About the application

Application number: 2025/93355	
What is the application for?:	Erection of 75 residential dwellings with associated landscaping, open space, hi
Address of the site or building:	Land off, Woodward Court, Mirfield, WF14 0PY
Postcode:	LS15 8ZB

Type of comment: An objection	
Do you wish your comments to be published on the website anonymously?	Yes
Existing Network The Traffic Assessment seeks to justify the development by painting an erroneous picture of a very lightly used local road network barely impacted by the additional traffic created. Section 2 describes the local road network but either underplays the impact of parked vehicles or incorrectly describes the available capacity. The following reflects the reality: Wellhouse Lane: Woodward Court to Jenny Lane – impacted by parked cars with very poor visibility at the bend immediate above the school. Woodward Court to Hepworth Lane – impacted by parked cars with a limited length where two-way traffic is possible. Hepworth Lane to Flash Lane – effectively single lane with passing places at the Cricket Club and Grove Street. No raised footways meaning the footway operates as an extension of the carriageway. Hepw

Image 2.3 Proposed Hepworth Lane Site Egress

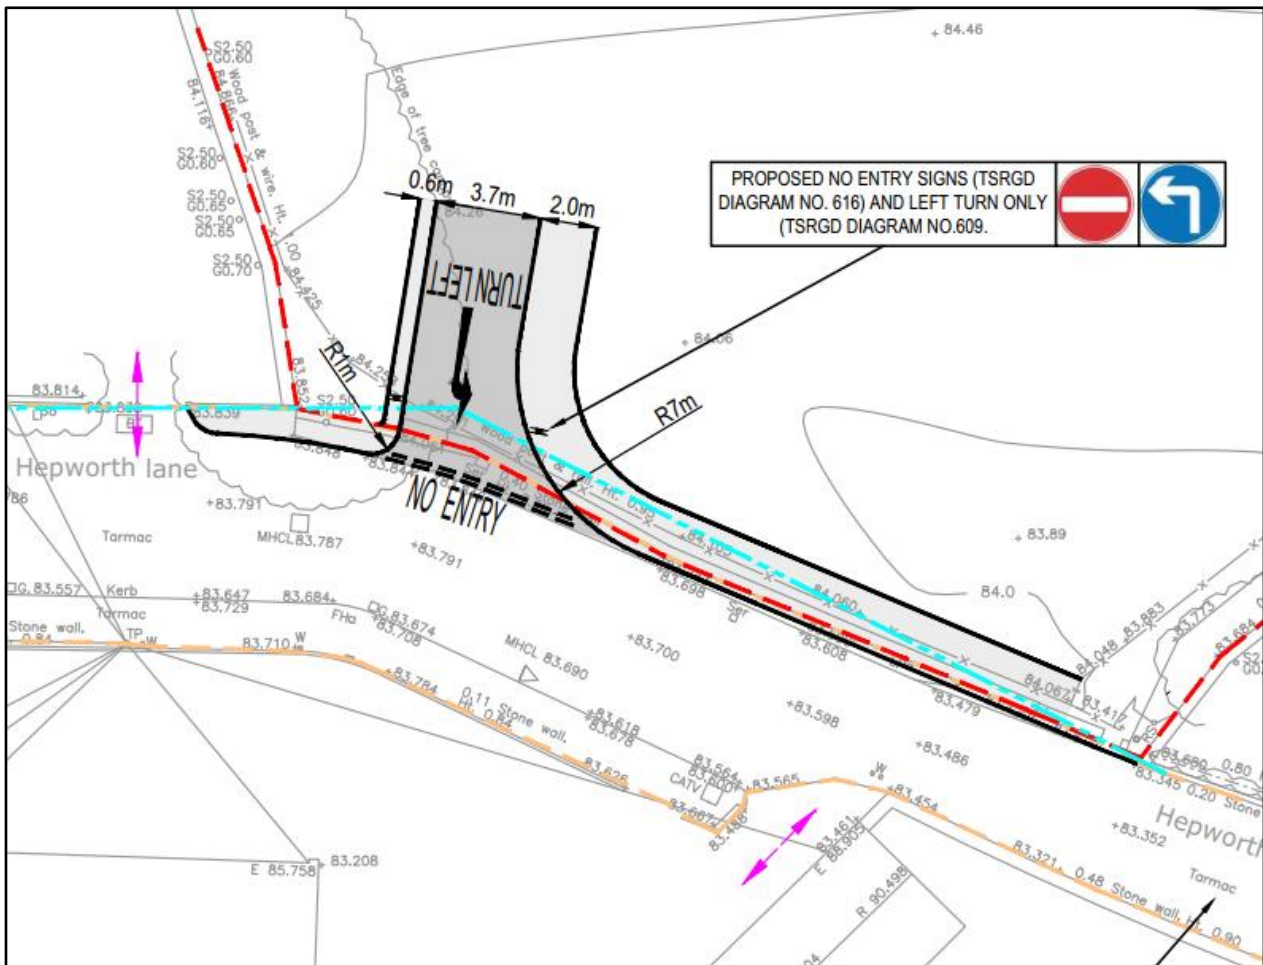
Southern exit onto Hepworth Lane.

The Assessment suggests that the estate road will attract traffic away from Wellhouse Lane. This would force traffic onto the eastern end of Hepworth Lane which is of insufficient width for two way traffic and has no footways. This would appear to be a fundamentally unsafe proposal.

The estate road itself will attract cars at school drop off time which inevitably will mean a row of parked cars down one side. The road is not engineered for through traffic and this will cause further vehicle and pedestrian conflict.
